This latest application seeks conversion of Kents Yard former agricultural buildings to form two dwellings and is a resubmission of the refused CM/28/16/PL.

**From:** [planning.responses@arun.gov.uk](mailto:planning.responses@arun.gov.uk) [<mailto:planning.responses@arun.gov.uk>]  
**Sent:** 23 June 2017 16:04  
**To:** SU Local Development  
**Subject:** Planning Consultation on: CM/19/17/PL

**Site Address:**                      Kents Yard Brookpit Lane Climping BN17 5QT

**Description of Works:**                      Conversion of former agricultural buildings to form two dwellings (Revised design). Resubmission following CM/28/16/PL. This application affects the setting of a Listed Building.

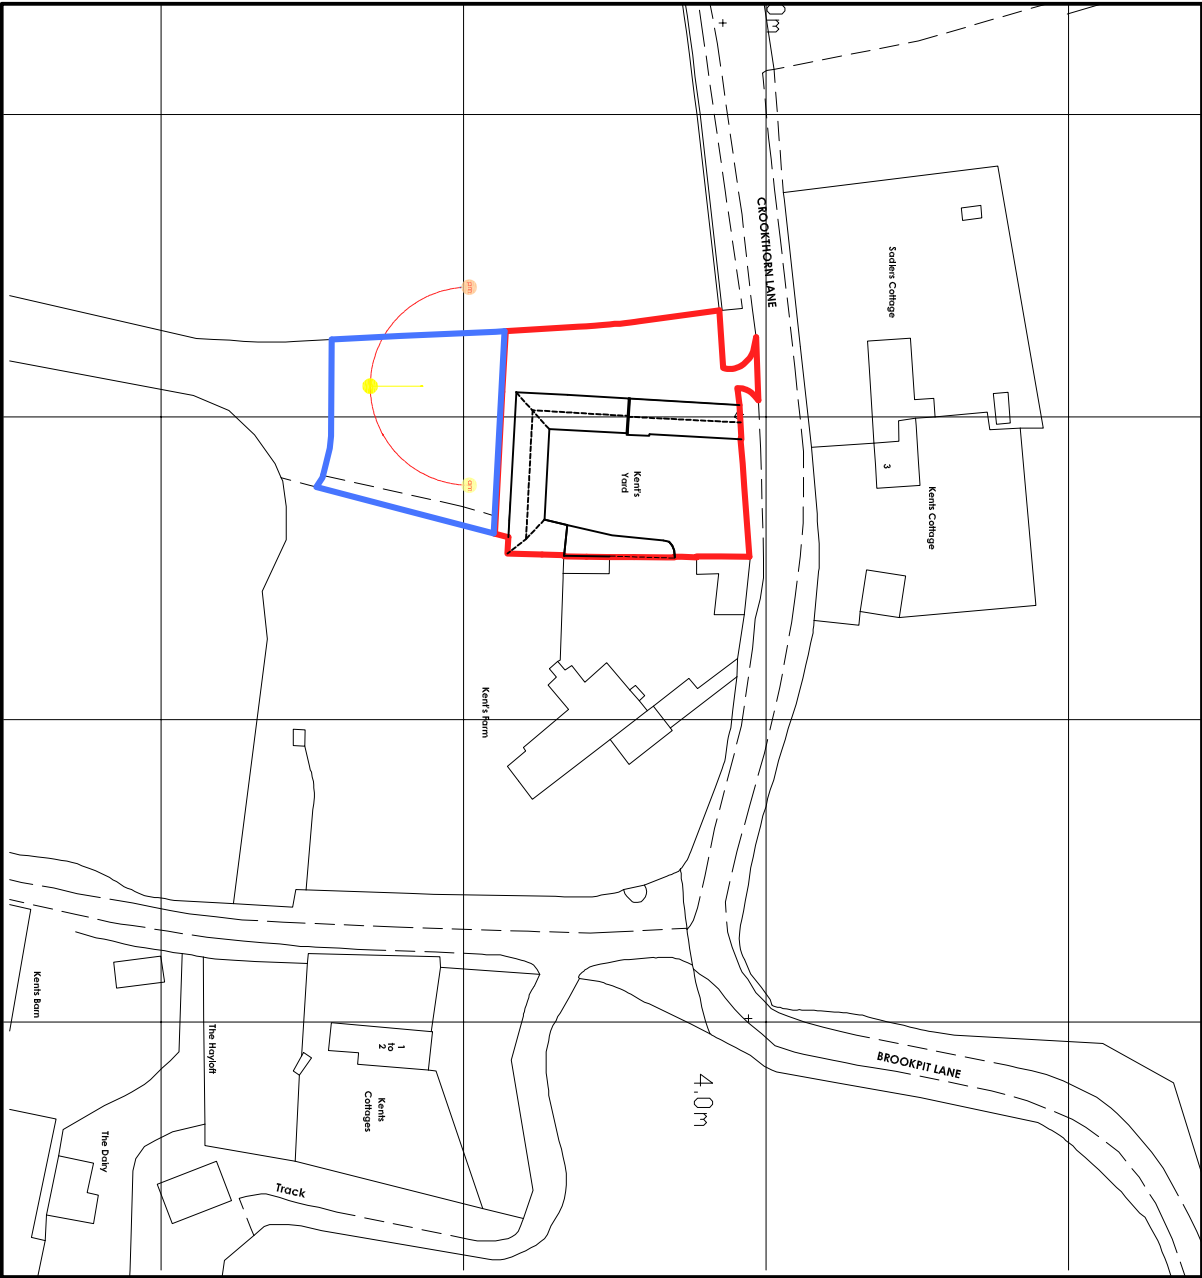
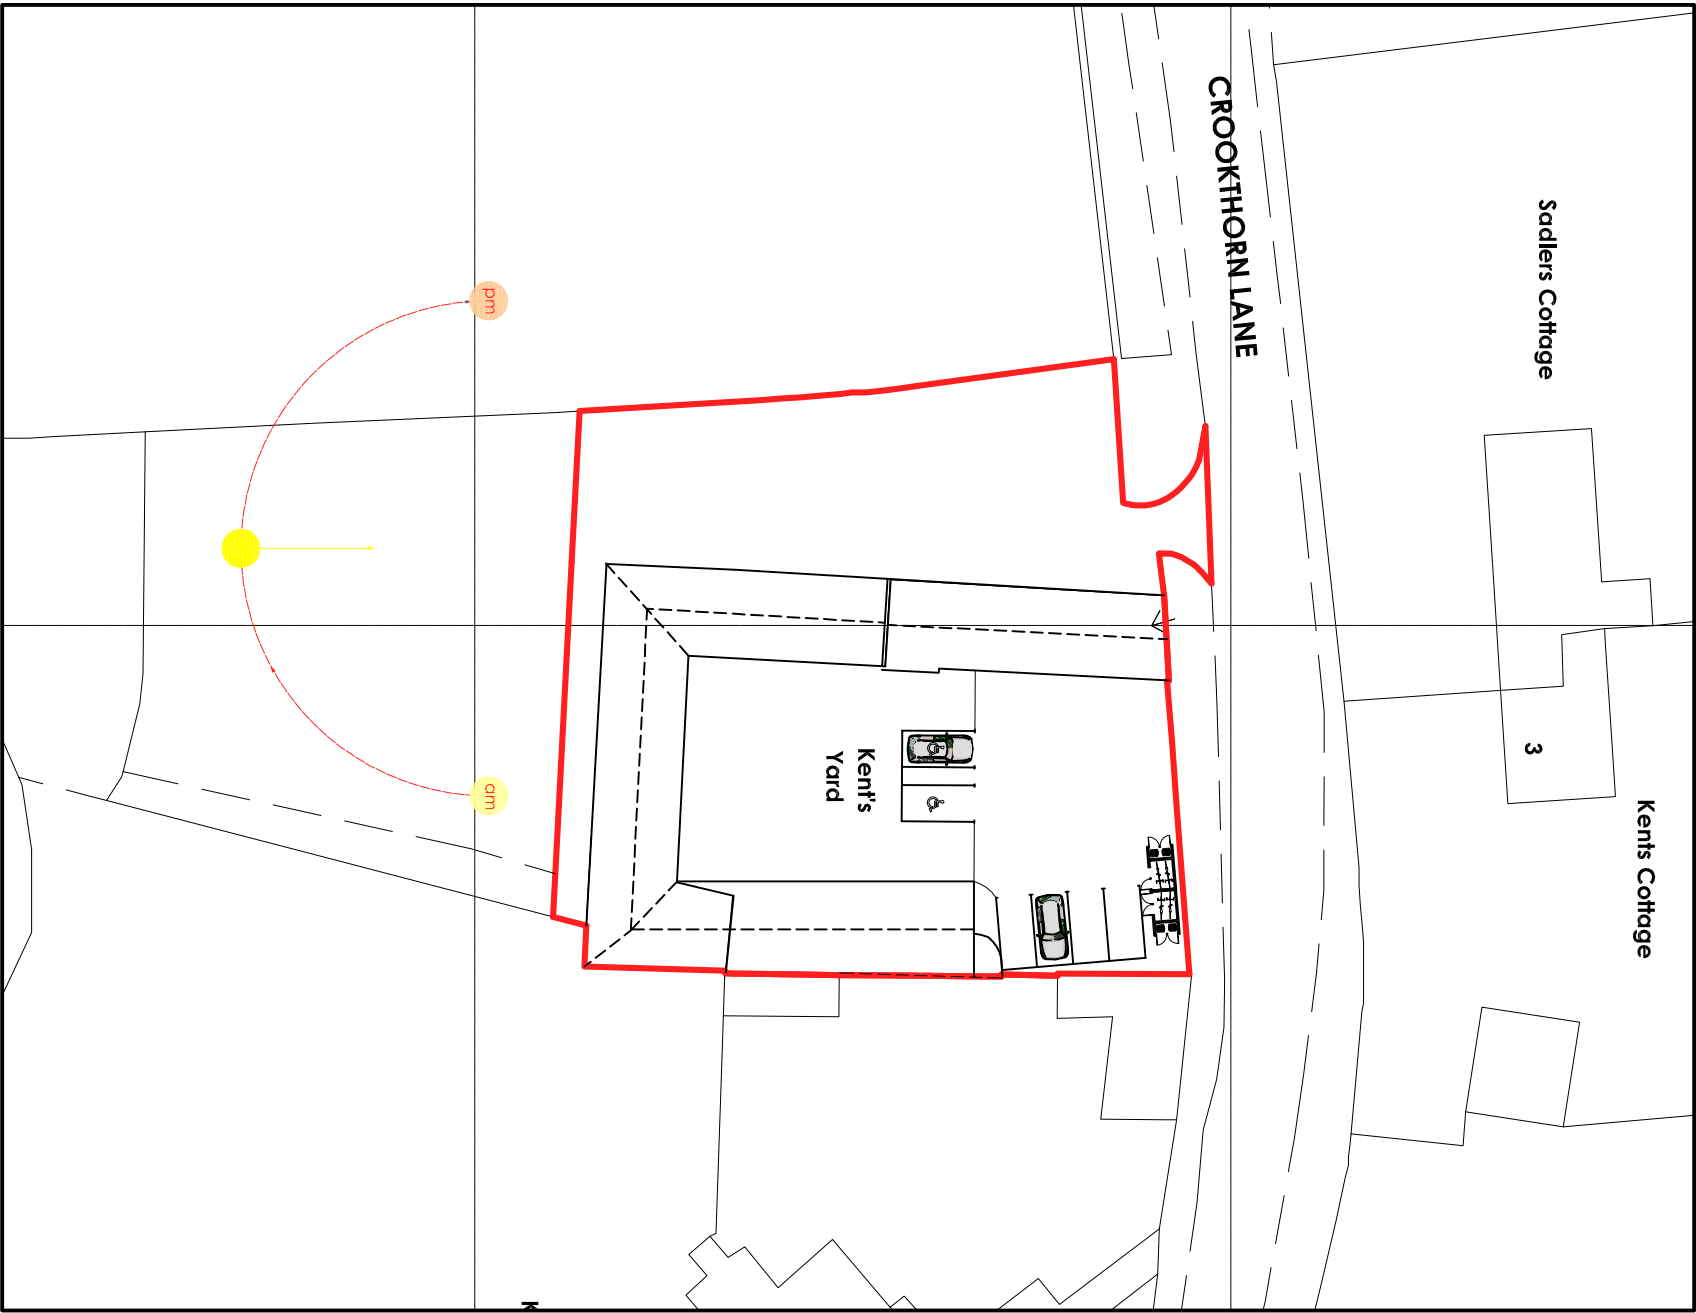
Each dwelling would be allocated two off street car parking spaces. The site plans provided demonstrate how the hardstanding turning area is large enough to accommodate at least two additional vehicles with extra room for disabled access. The on-site vehicle parking provision would be considered adequate to meet the need of the development.

The site plans provided also demonstrate appropriate secure and covered cycle parking facilities.

No part of the development shall be first occupied until the car parking has been constructed in accordance with the approved site plan. These spaces shall thereafter be retained at all times for their designated purpose.

No part of the development shall be first occupied until covered and secure cycle parking spaces have been provided in accordance with the approved site plan. This facility shall thereafter be retained at all times for their designated purpose.
